From: Jeff Tarling
To: Jean Fraser
CC: David Margolis-Pineo
Date: 5/15/2015 10:48 AM
Subject: Congress Street Jewish Center

I have reviewed the proposed landscape plan for the Jewish Neighborhood Center on Congress Street and offer the following recommendations:

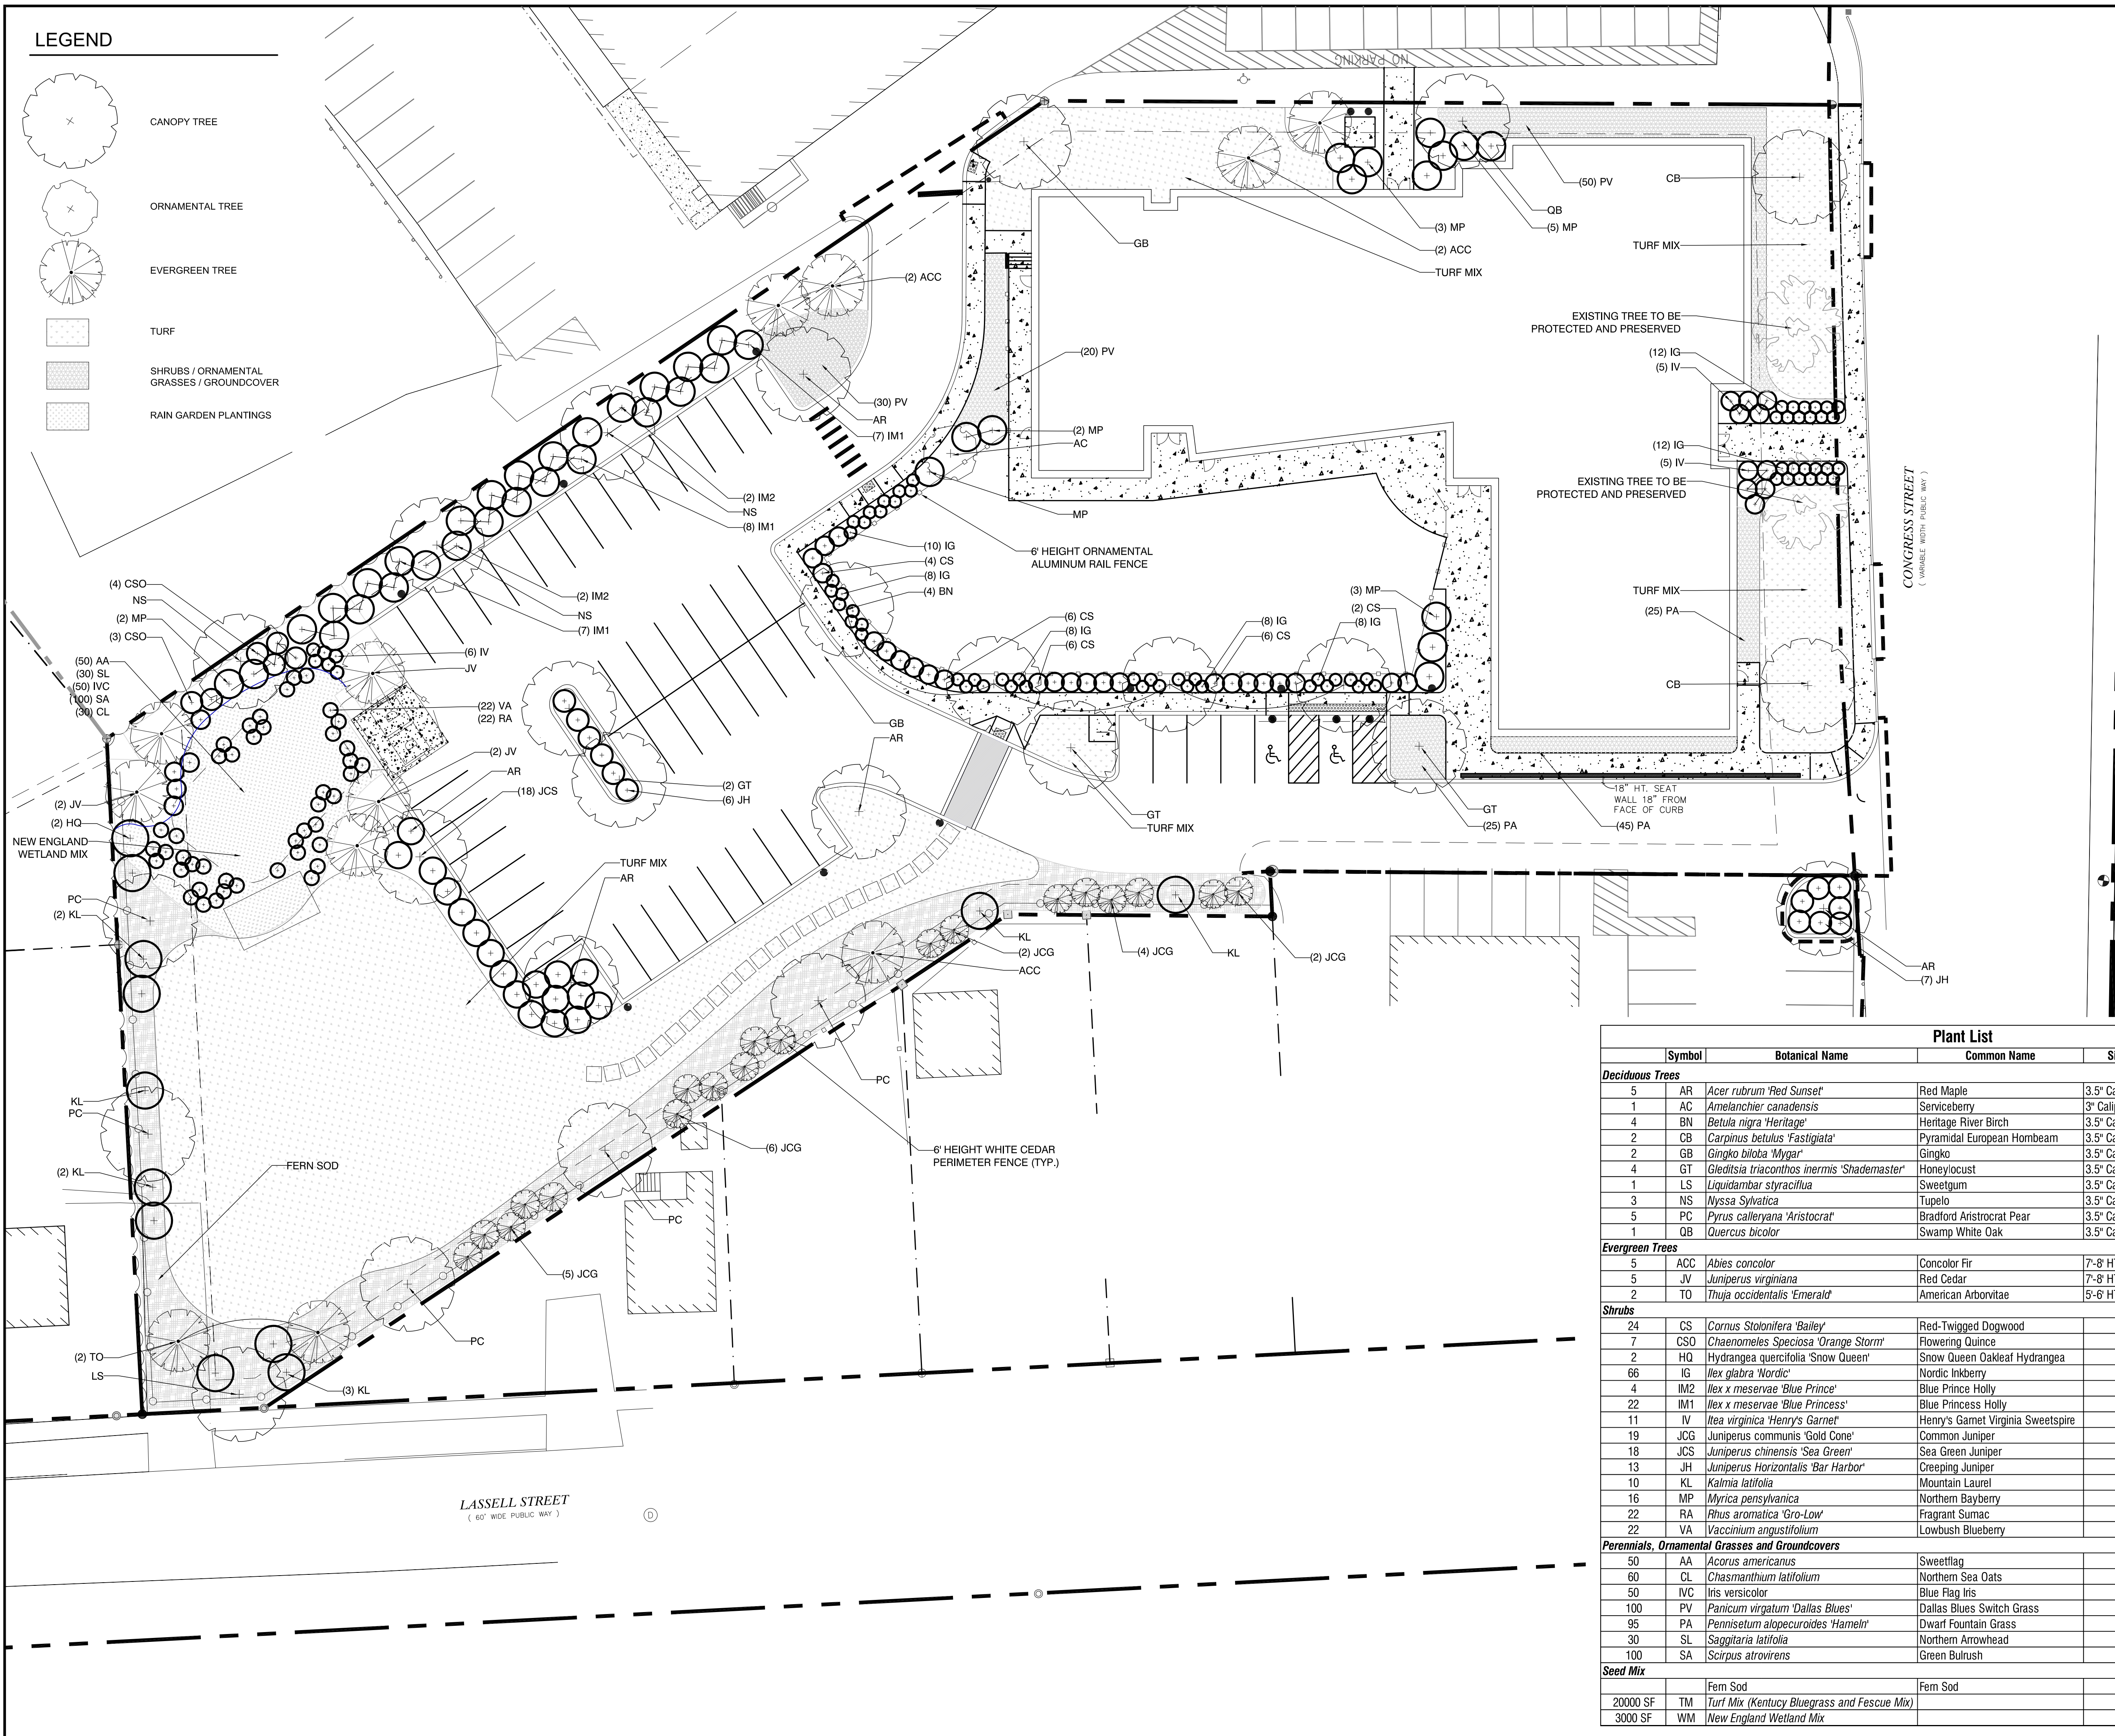
Looking at the back property line and the graphic showing a proposed fence, which is recommended, wanted to request a fence spec. My first thought is that the fence should be wooden 6' in height or something equal.

The project removes several mature trees on the side entranceway and does not appear to replace them. Looking at the space it appears to be wide enough that several, 3 - 4 small trees such as Magnolia, Dogwood or Cherry could be successfully planted back in this location. We have also seen good use of the several upright Oak varieties that stay very narrow but with height that could help replace the lost trees, see: <http://www.jfschmidt.com/pdfs/regalprinceoak.pdf> Improving this space should be a priority. Also noted that a small center landscaped island near the entranceway could be used to improve or define the drive into the site.
